Application for a non-material amendment following a grant of planning permission.

Erection of front extension to create first floor balcony, erection of rear Juliet balcony, demolition of existing conservatory with changes to external materials and wall finishes.

Reference number:	EP/2/21/HH
Date of decision	19/03/2021

Alteration of front balcony and rear Juliet balcony doors from being single doors with windows either side, to double doors.

Drawing Number: 1282.02 g

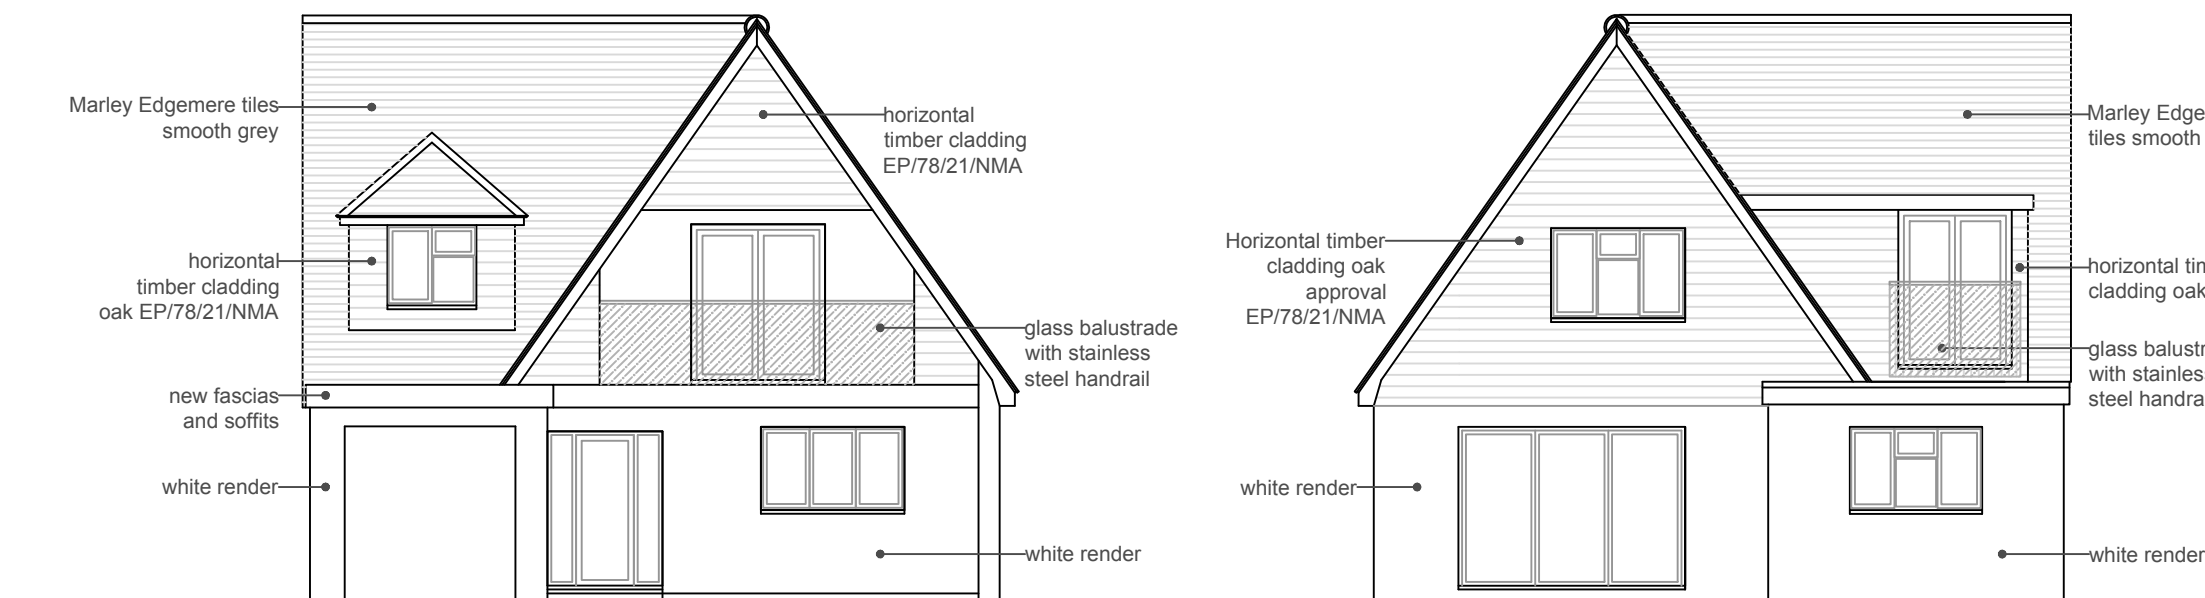
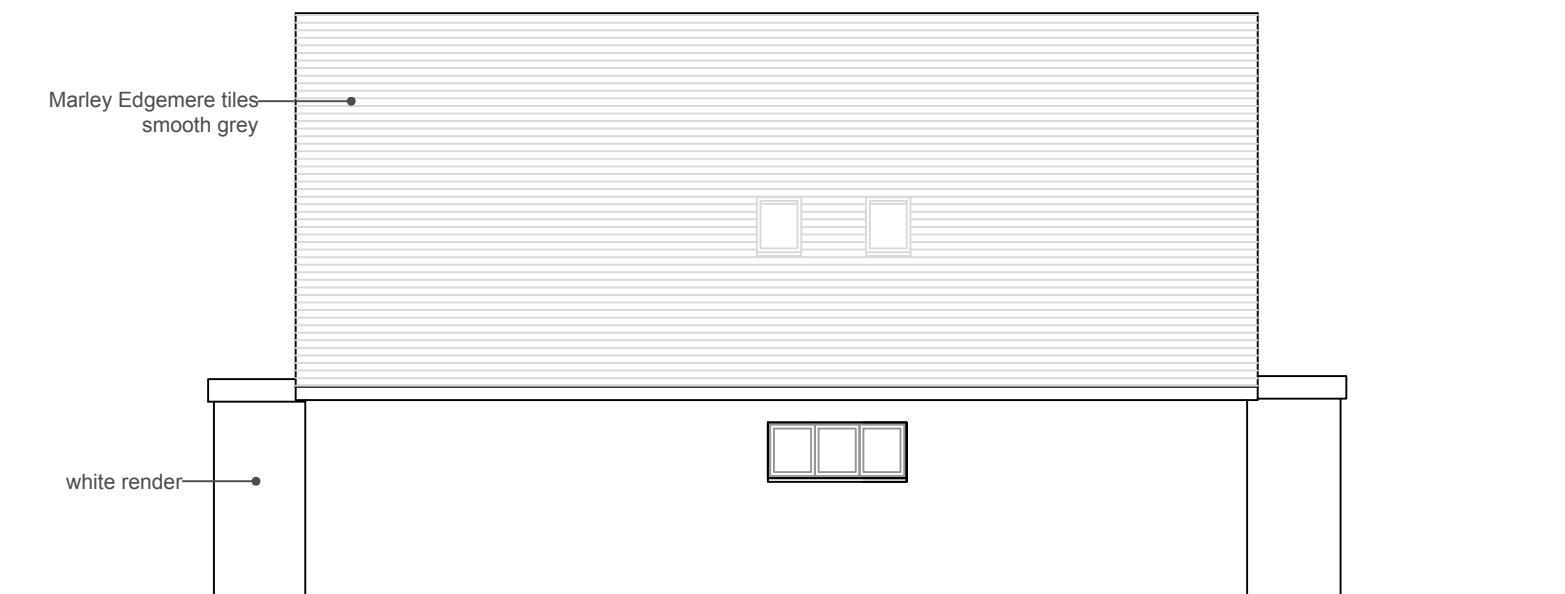
For the 2 balcony doors (front and back) we decided not to have single doors with 2 side windows, and when given the option by the window company to have 2 doors rather than one instead, we opted to do that without realising we may need approval for this.
